# Observations Response Document

1. Codling Wind Park Ltd., a joint venture project between EDF Renewables and Fred. Olsen Seawind, is proposing to develop the Codling Wind Park (CWP) Project, a proposed offshore wind farm (OWF) located in the Irish Sea approximately 13–22 km off the east coast of Ireland, at County Wicklow.

10. This document has been prepared in response to the Commission’s invitation to respond to the submissions received and observations made in relation to the CWP Project planning application.
11. The document summarises the matters raised and provides a response to these, with cross reference where appropriate to the relevant documents that make up the CWP Project planning application, including the EIAR and NIS, and other documents that make up the Applicant’s FIR response. **Table 1-1** below provides an overview of the documents that make up the FIR response.

Export Cable Installation at Deeper Burial Area
Scale 1:50

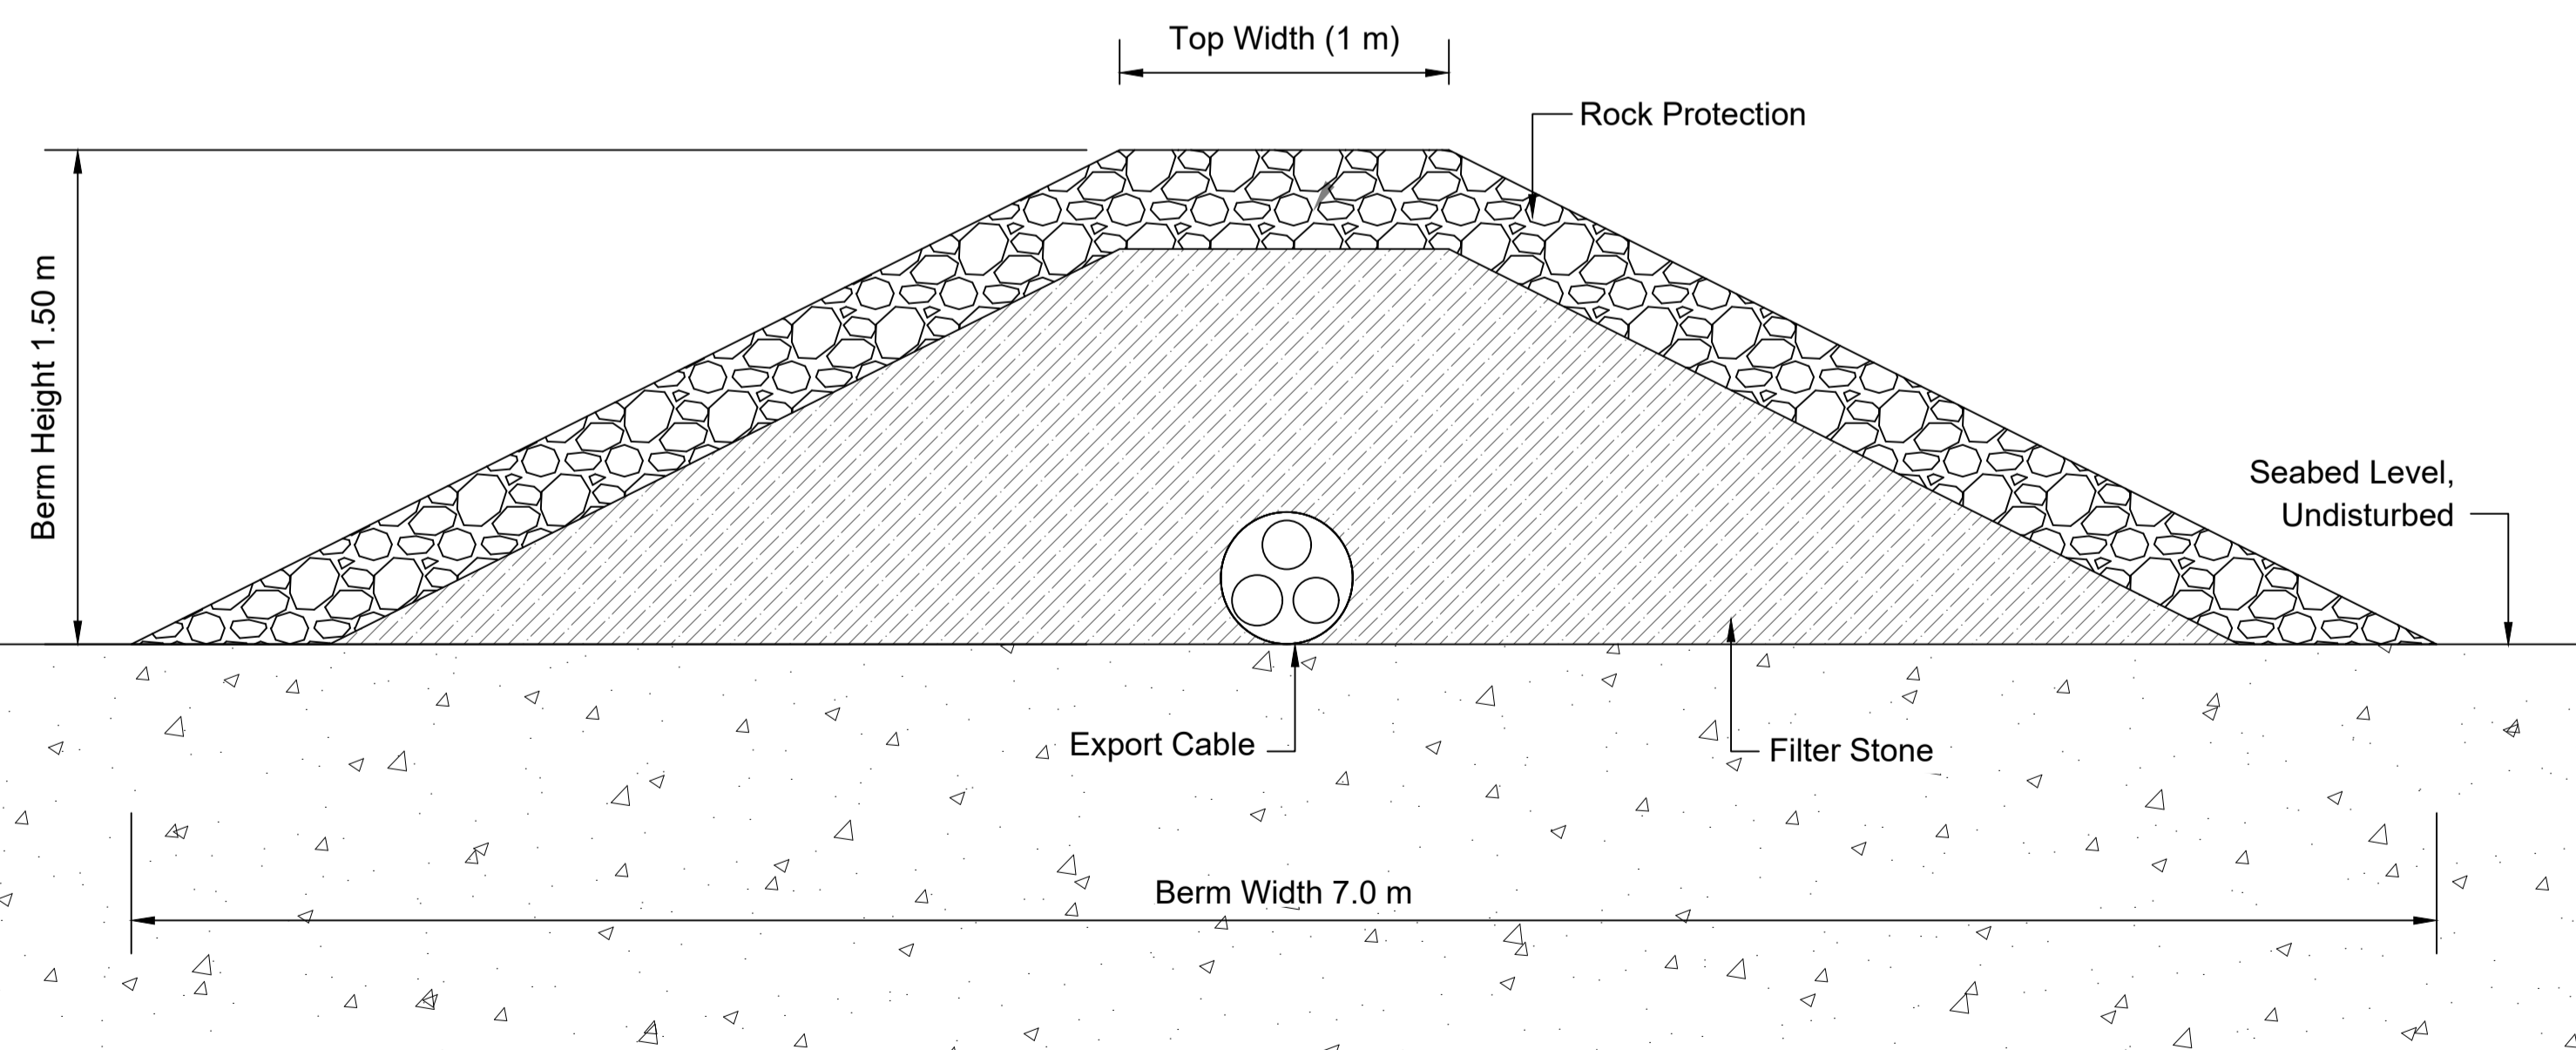
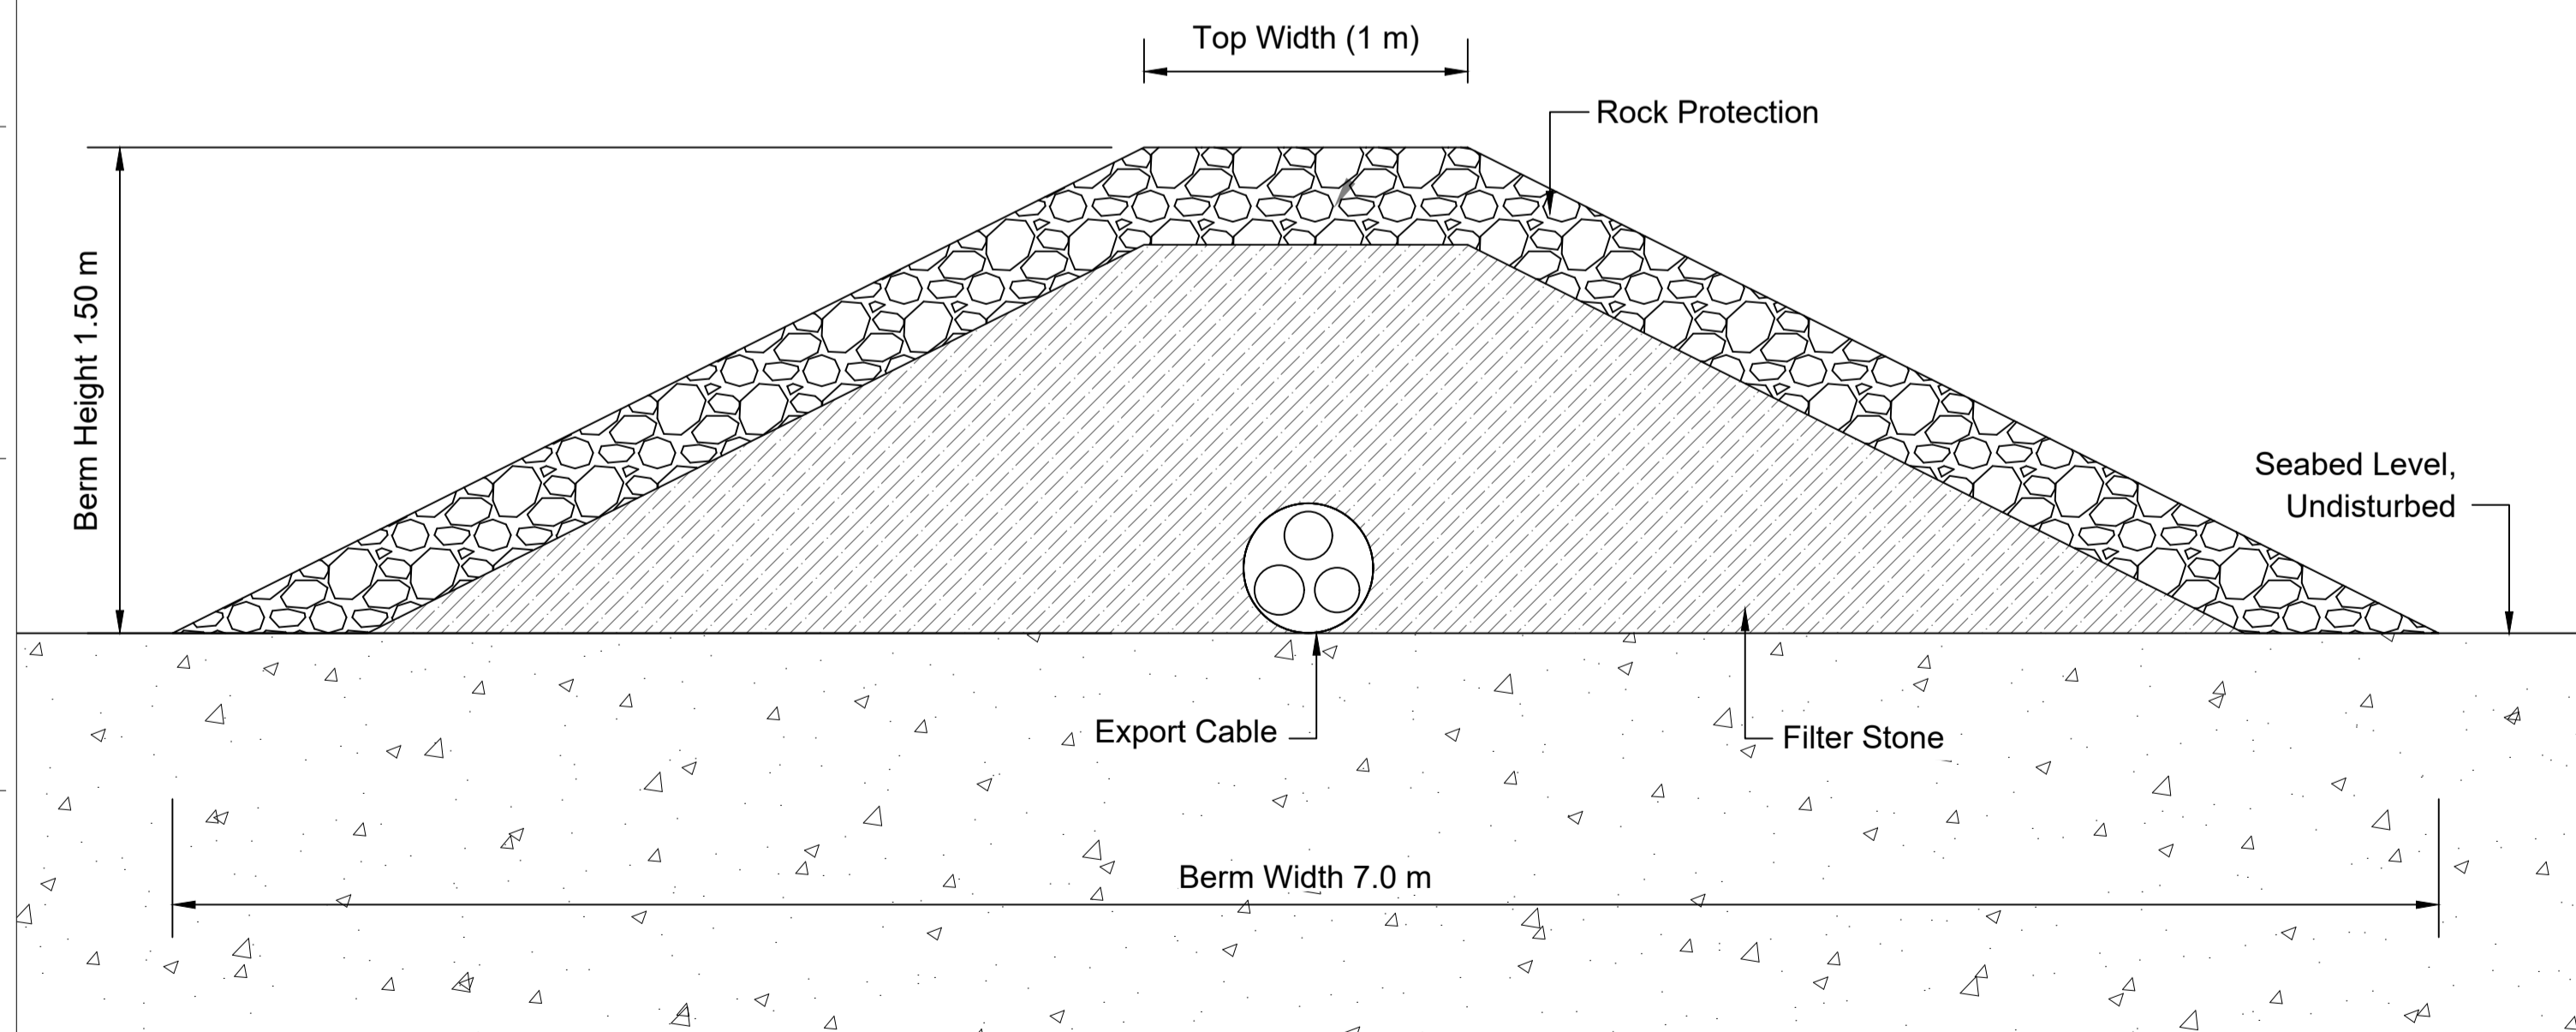
39. DLRCC seeks clarity on the minimum depth of cover of the export cables in the zone of greater burial depth where this interfaces with Dun Laoghaire Harbour's channel dredge footprint to accommodate cruise ships and select commercial vessels within the harbour in the short to mid-term future.
40. DLRCC notes that the planning application includes some inconsistencies with regards to the depth of the transmission infrastructure trench within the zone of greater burial depth. It is considered essential

that the transmission trench is installed at adequate depths in order to safeguard future operations of Dun Laoghaire Harbour, a piece of strategic infrastructure in the County.

48. DLRCC seeks clarity on the intention to lay cable protection within the zone of greater burial depth where the target burial depth is not achieved. In their view, secondary protection will not be feasible in this area, as placement of rock or concrete mattress on the cables would conflict with DLRCC’s required dredge depths.

41. The CWP Project has sought planning permission for a trench depth of 3m in the zone of greater burial depth, as opposed to 3m depth of cover. The Applicant also recognises that certain parts of the planning application refer to a trench depth of 3m, whilst other parts refer to 3m depth of cover.

42. Updates to the planning application documents listed below have been made to confirm the intention to lay offshore export cables at a *minimum depth of cover of 3m* in the zone of greater burial depth, and to ensure this depth of cover is consistently described across the suite of documents. These updates have been made in response to the matters raised by DLRCC, and in response to item 18a of the Commission's FIR.

- Revision A of planning drawing 0063 Export cable burial and protection details included with the CWP Project planning application is superseded by Revision B in the Other Documents and Drawings that support the Applicant's FIR response.

49. Revision A of planning drawing **0063 Export cable burial and protection details**, included with the CWP Project planning application, has been updated and is superseded by Revision B in the **Updated Planning Drawings** that support the Applicant’s response to the Commission’s FIR. The drawing has been updated to confirm and clarify that the Applicant does not intend to install secondary cable protection in the zone of greater burial depth.
